**KIRKLEES METROPOLITAN COUNCIL
INVESTMENT & REGENERATION SERVICE**

Reference No: 2018/62/93980/W

Site Address: 12, Cambridge Road, Huddersfield, HD1 5BU

Description: Change of use from house of multiple occupation to guest house and formation of dormers to rear

PROPOSED REAR.

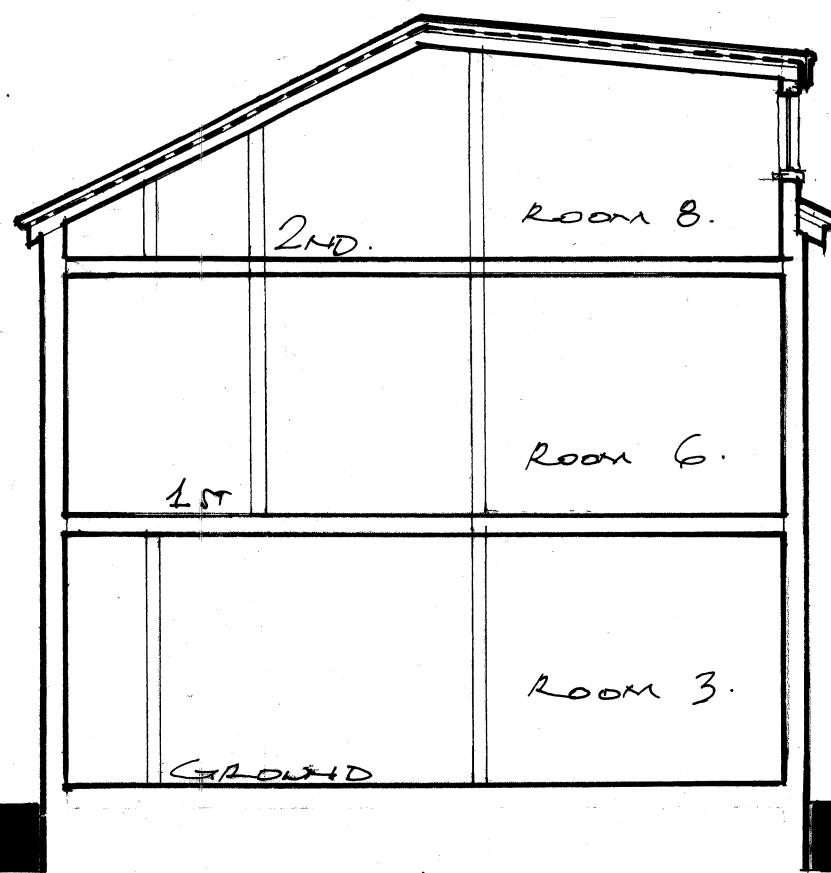
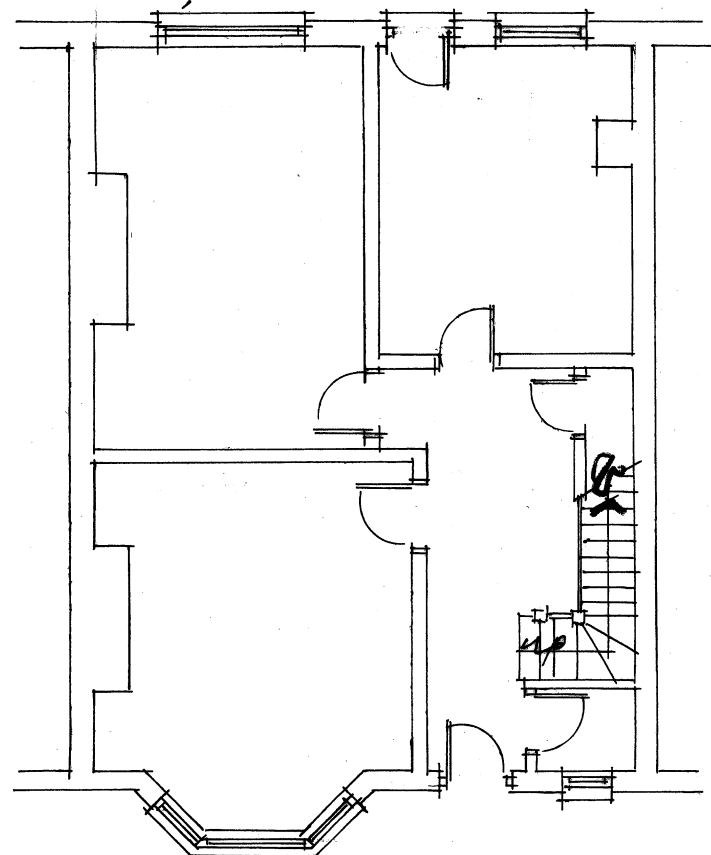
The twin dormers would each have a double pitched roof, with only minimal clearance (about 100mm) above the gutter line and below the ridge. The roofing materials and the cladding materials for the dormer would match the existing building.

2 – Impact on visual amenity: An earlier amendment showed a large box dormer formed to the rear. This would have been unsightly and out of keeping with the row, which at present has an unaltered roofline at the rear. This being a large HMO, not a dwelling house, there is no fall-back position for roof extensions under permitted development rights, so any such scheme must be assessed on its own merits.

The plans have been altered to show a pair of dormers with pitched roofs. It is considered that these would respect the appearance and character of the existing building. The agent has confirmed that the cheeks are tile clad. This is considered acceptable as long as a suitable material (blue slate or imitation blue slate) are used.
